Appeal Decision

Appeal Ref: 6008246

21 Green Lane, Uxbridge, Hillingdon UB8 3ED

- The appeal is made under section 78 of the Town and Country Planning Act 1990 (as amended) against a refusal to grant planning permission.
 - The appeal is made by Mr Harun Mehra against the decision of the Council of the London Borough of Hillingdon.
 - The application Ref is 49724/APP/2025/3002.
 - The development proposed is the change of use of a dwellinghouse (Use Class C3) to a House in Multiple Occupation (HMO) for 5 occupants (Use Class C4).
-

DRAWING  
PROPOSAL SITE PLAN AND ELEVATIONS

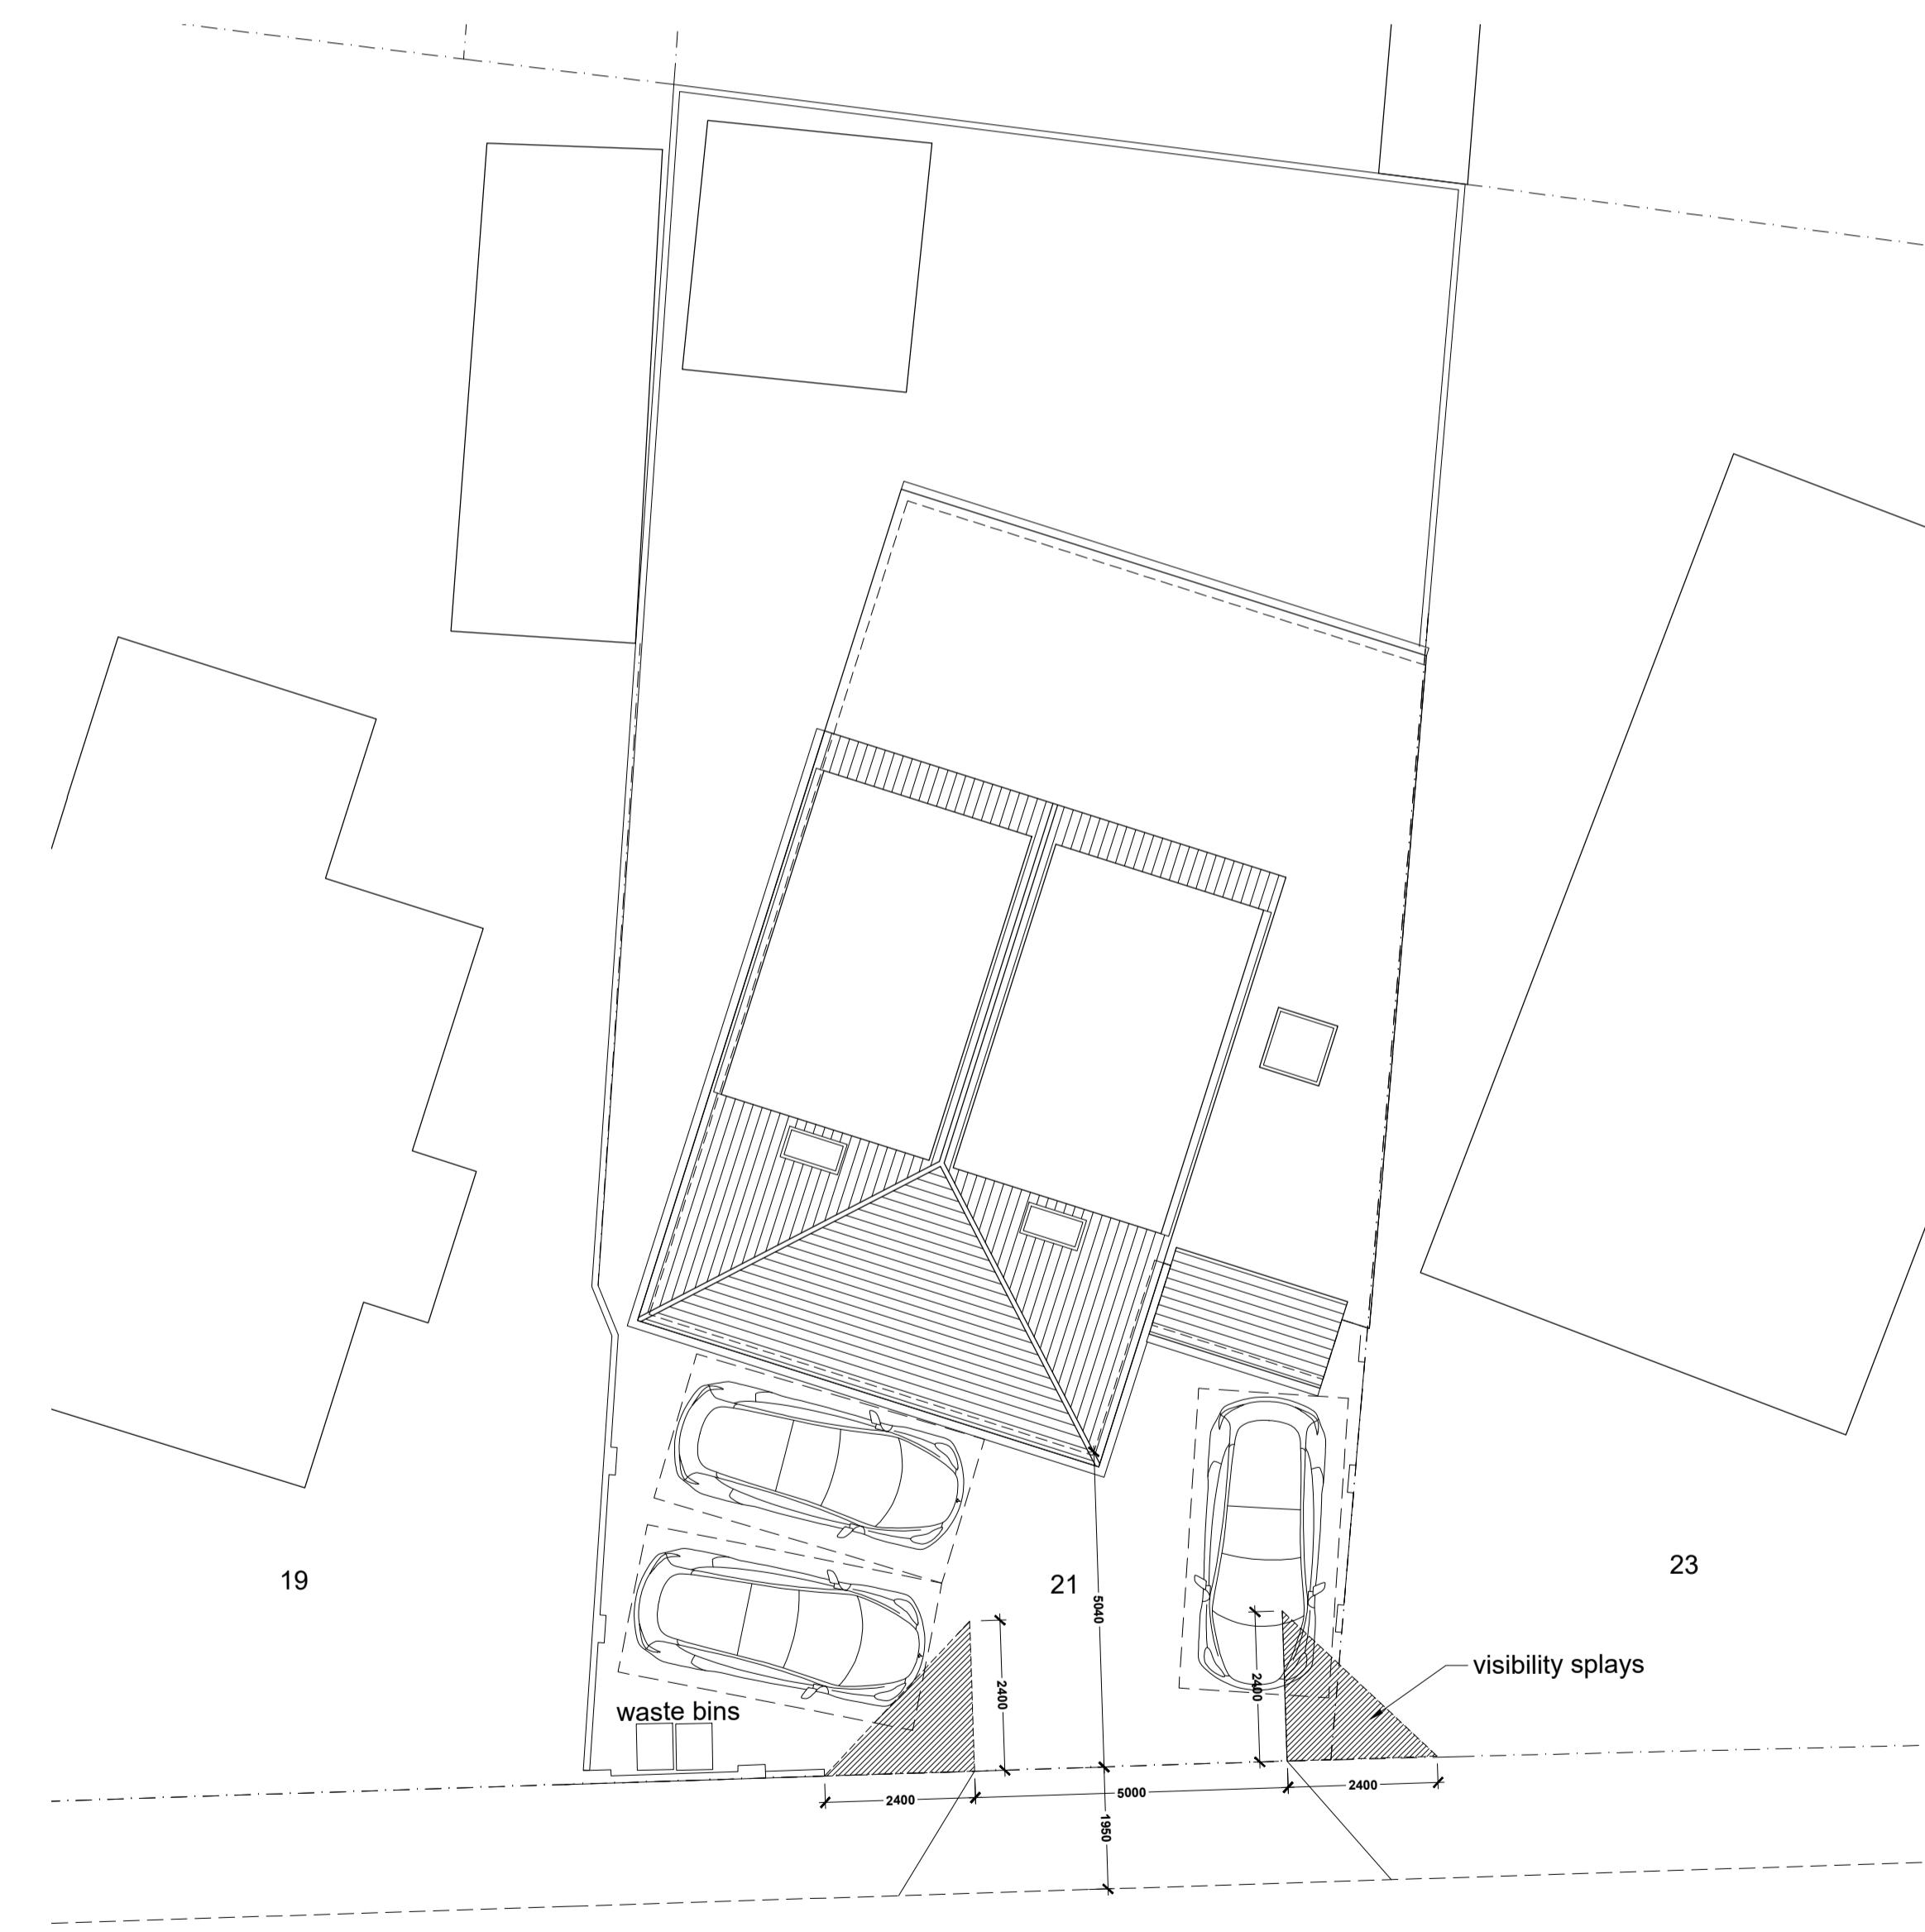
7. Many of the dwellings along Green Lane are bungalows of modest proportions. Some have been extended, but they retain compact footprints and are sited close together, on narrow plots with small gardens and driveways. Externally, the appeal site is hard surfaced, with block walls marking the boundaries. At the front, those are low, which allows easy visibility across the boundary. Both of the adjacent bungalows include ground floor windows close to and overlooking the appeal site, including some in the side elevation of 19 Green Lane which face directly towards the front driveway.

11. The driveway could accommodate three cars, which accords with the Council's standards for HMOs. The layout appears rather tight but may allow for each vehicle to be moved independently with care, once the access had been widened, as proposed. No highway safety harm has been alleged and there is on-street parking in the surrounding streets. Occupiers would have some options for active travel despite the relatively low Public Transport Accessibility Level score, and cycle storage would be provided.

12. Nevertheless, there would be nothing to prevent all five occupants from operating their own private motor vehicle, should they be in a position to do so. They would also have a strong incentive to park conveniently on the driveway whenever it is available, or directly outside the property. That would tend to intensify the likely level of comings and goings on and around the limited driveway area.

14. Taking those factors into account, the assertion in the Transport Statement² and Noise Impact Assessment that vehicle movements would be comparable to those generated by a family household is not convincing, when considered from the perspective of neighbouring occupiers. The overall number of additional vehicle movements may be modest, as a proportion of total traffic along Green Lane. However, the very close relationship between the driveway of the appeal site and ground floor windows of the adjoining dwellings means that such activity would be particularly intrusive.

DRAWING
PROPOSAL PLANS

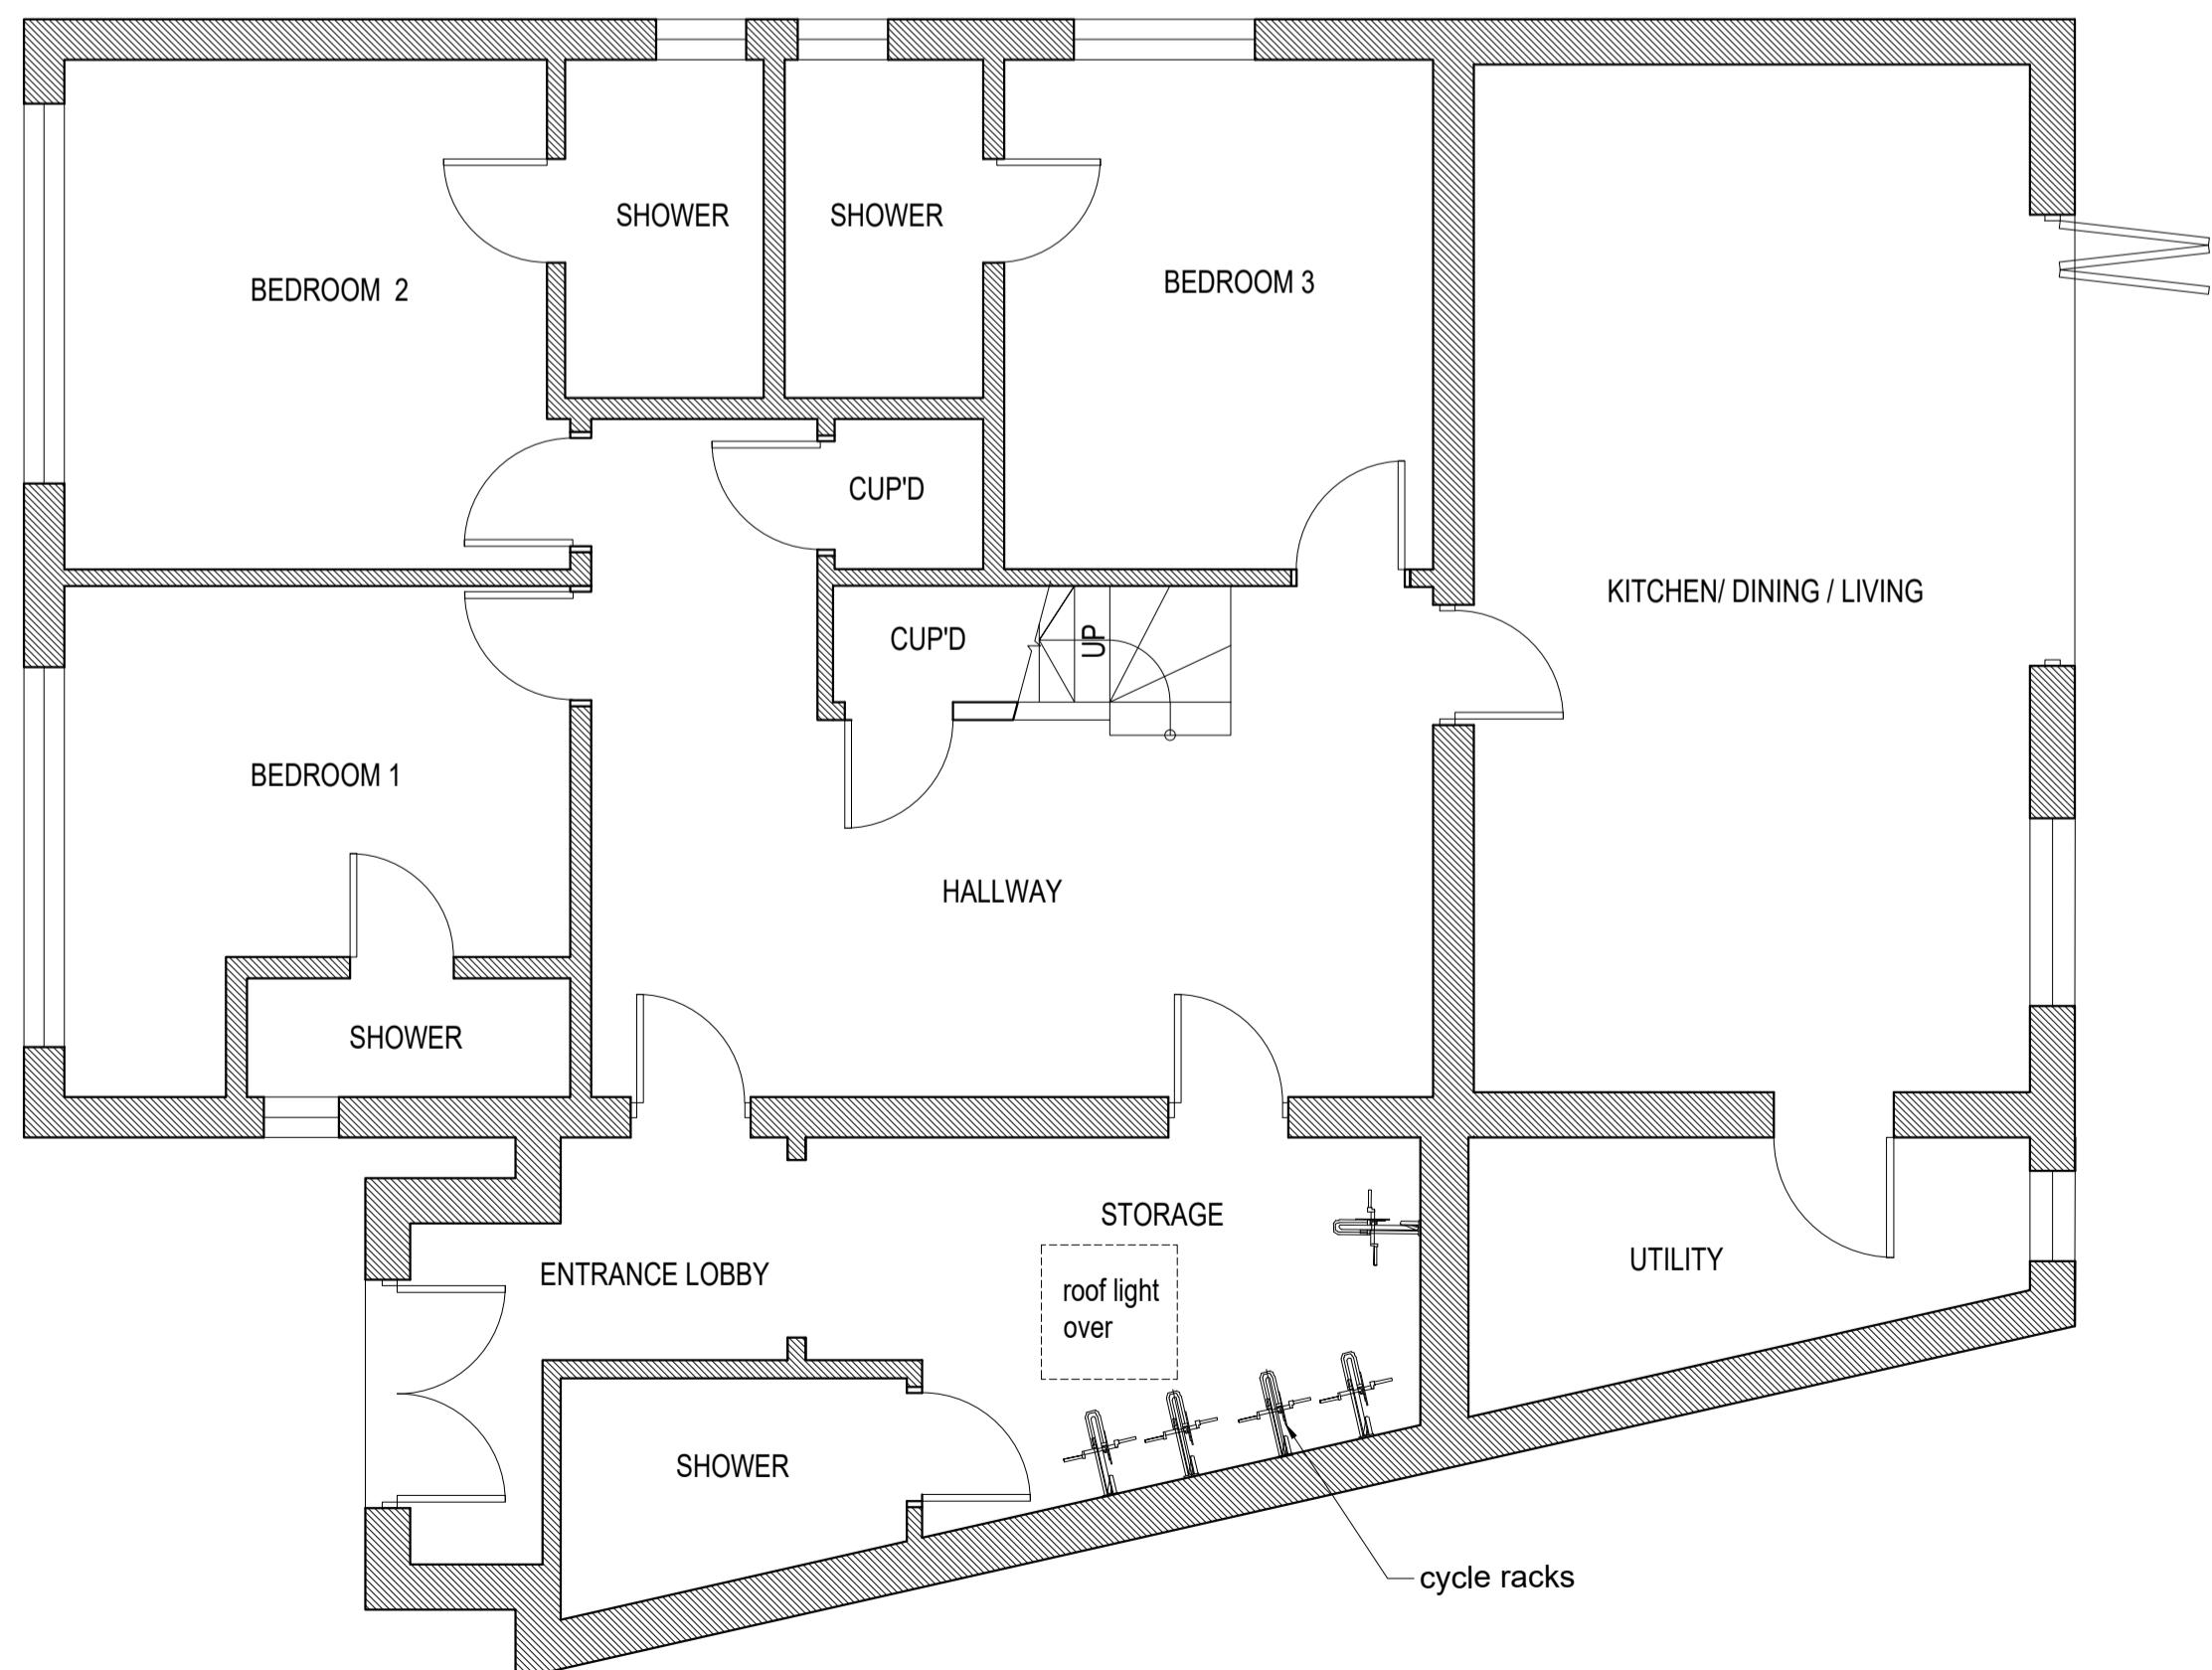
6. The appeal property is a bungalow which has been extended at roof level and at the rear. It currently provides five bedrooms, a kitchen/living space, a snug and an upstairs room described as a study. There is a detached outbuilding at the rear, which was furnished with desks and chairs at the time of my inspection. In use as a 5-person HMO, it is proposed that much the same layout would be retained, but that the snug would be adapted to provide cycle storage.
